**From:** [REDACTED]  
**To:** [Norfolk Vanguard](#)  
**Subject:** Submissions for prelim Hearing 10th Dec Attn Tracey Williams  
**Date:** 03 December 2018 11:45:31

**Item 3. Annexe B Nature of proposed development & Visual impact subsections & CA**

**From:** [REDACTED]  
**To:** [Norfolk Vanguard](#)  
**Subject:** Intention to speak at Open meeting. Evening Mon 10th Dec.  
**Date:** 03 December 2018 13:37:21

Title:  
Viewpoint 11:  
Hale Road, East of Holme Hale Hall

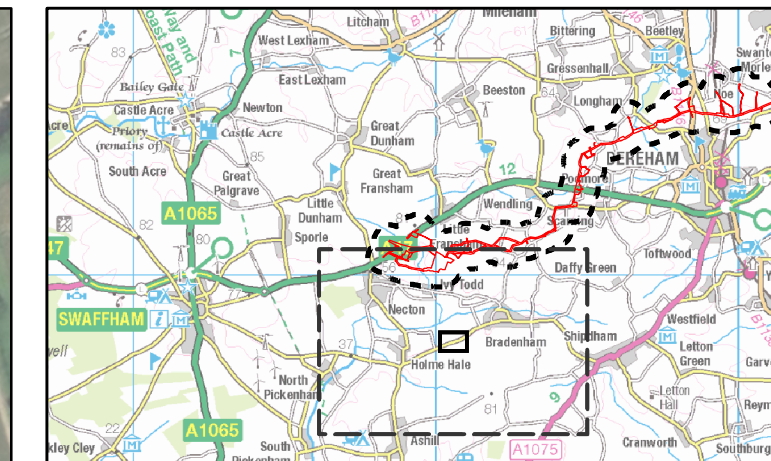
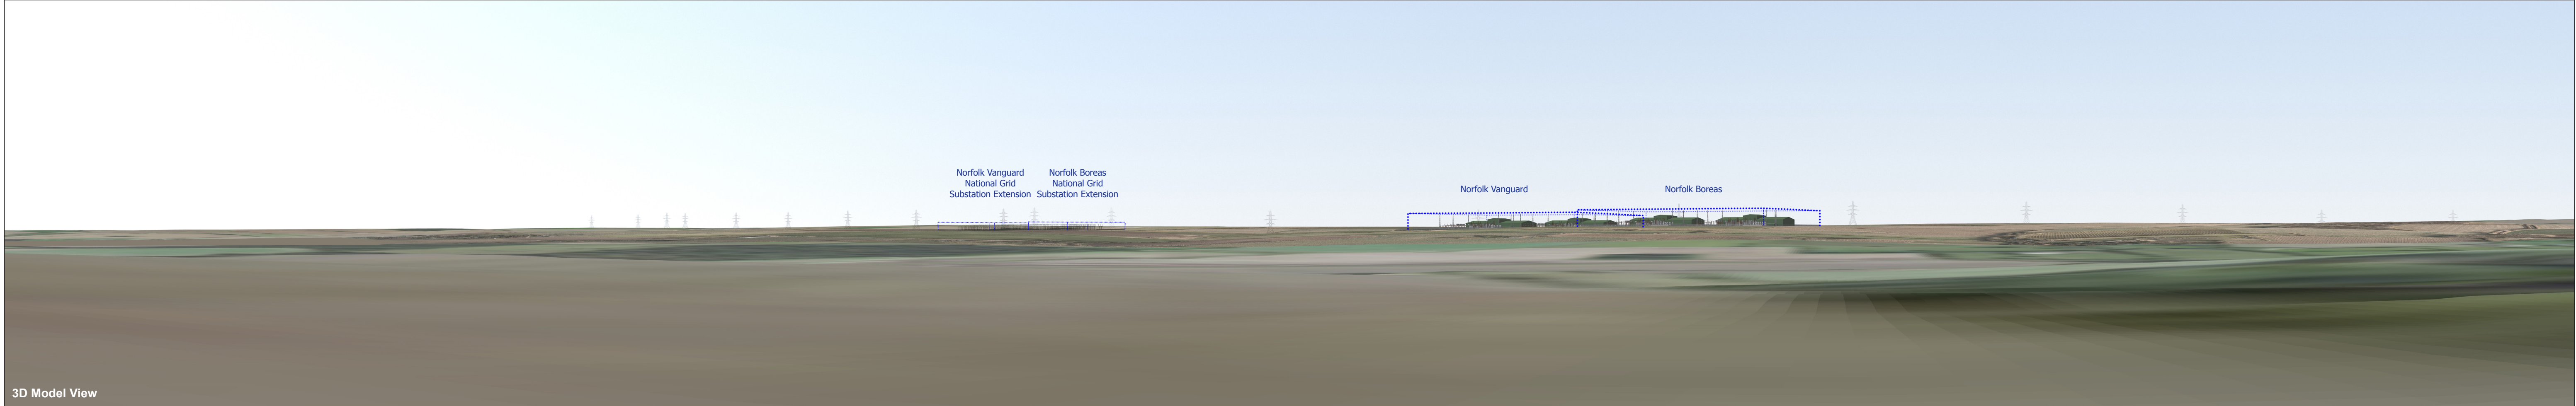
1) The "Viewpoint 11" taken at IP25 7EE used the presence of woodland to mostly obscure the view of the development. whereas, less than 200m to the east, the entire development, along with the existing substation, would be openly visible in full... The expansion of this, would be that further viewpoints have been found to have changed and there is contradiction between the Theoretical visibility map, which clearly shows the majority of the area in 'Highly Visible' blue shade, which includes almost the entirety of the village of Holme Hale, yet the text of the document plays this down, referring to a viewpoint by St Andrews Church, taken when the vegetation was overgrown and a hazard to the road and awaiting heavy cut back. Additionally, the 'FlipBook' photomontages available on the Vattenfall website included only those for options 1 and 4.. there was no photomontages for option 2, which is the option chosen by Vattenfall.
